**Re: SW Mesa Clinic—UNMH, 301 Unser Blvd NW, (K-10/D054),
Engineer's Stamp Date: 04/09/2010, Certification Date: 11-01-10**

**Re: SW Mesa Clinic-UNMH, 301 Unser Blvd NW,
Request for 90-Day Temporary C.O.—Approved
Engineer's Stamp dated: 4/09/10 (K-10/D054)
Certification dated: 11-01-10**

**Re: UNM Hospital SW Mesa Clinic Grading and Drainage Plan
Engineer's Stamp dated 4/9/2010 (K10/D054)**

SHEET TITLE
**GRADING AND DRAINAGE
 PLAN**

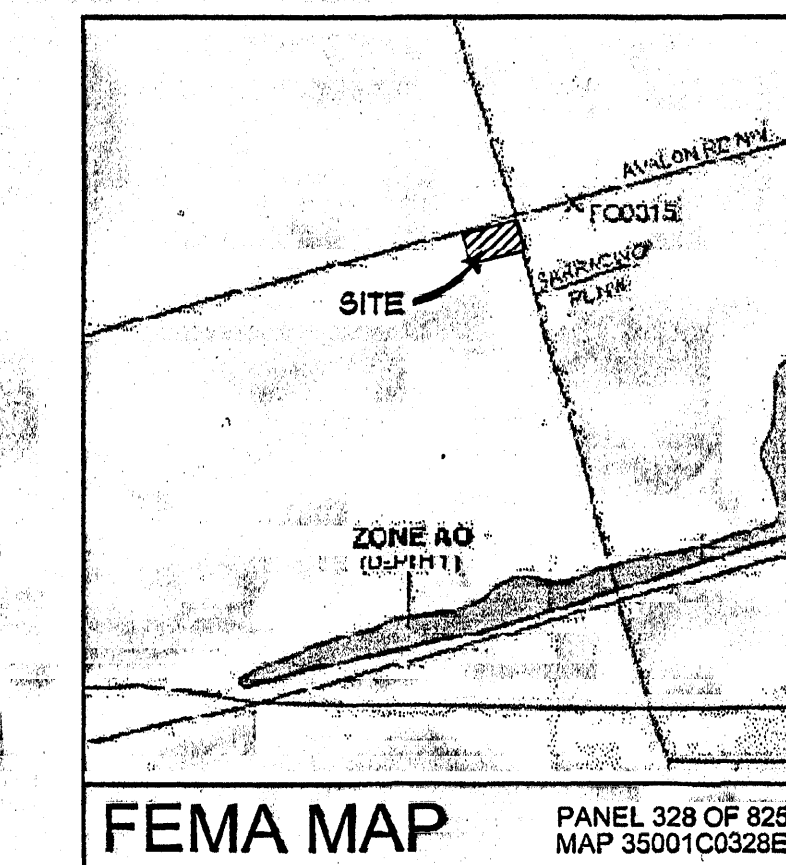
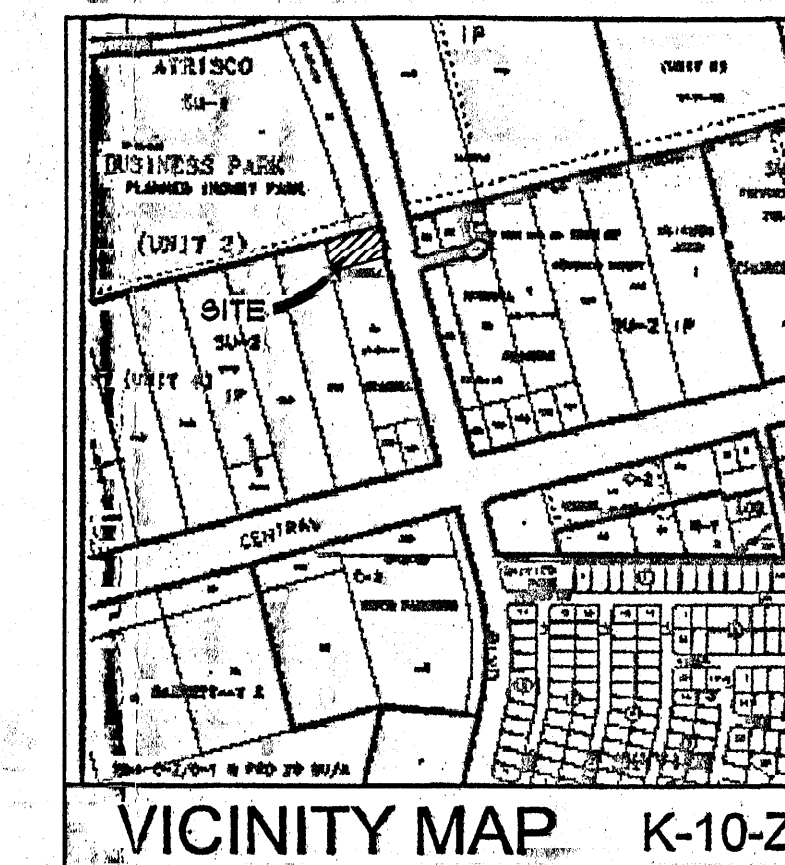
Prior to Permanent Certification the construction fencing will need to be removed and the spoil pile in the parking lot will need to be removed. It is my understanding that a work order is in place to install a deceleration lane in front of this property which removes the abandoned drive pad. Please with the next submittal call out this work order number and limits for the deceleration lane.
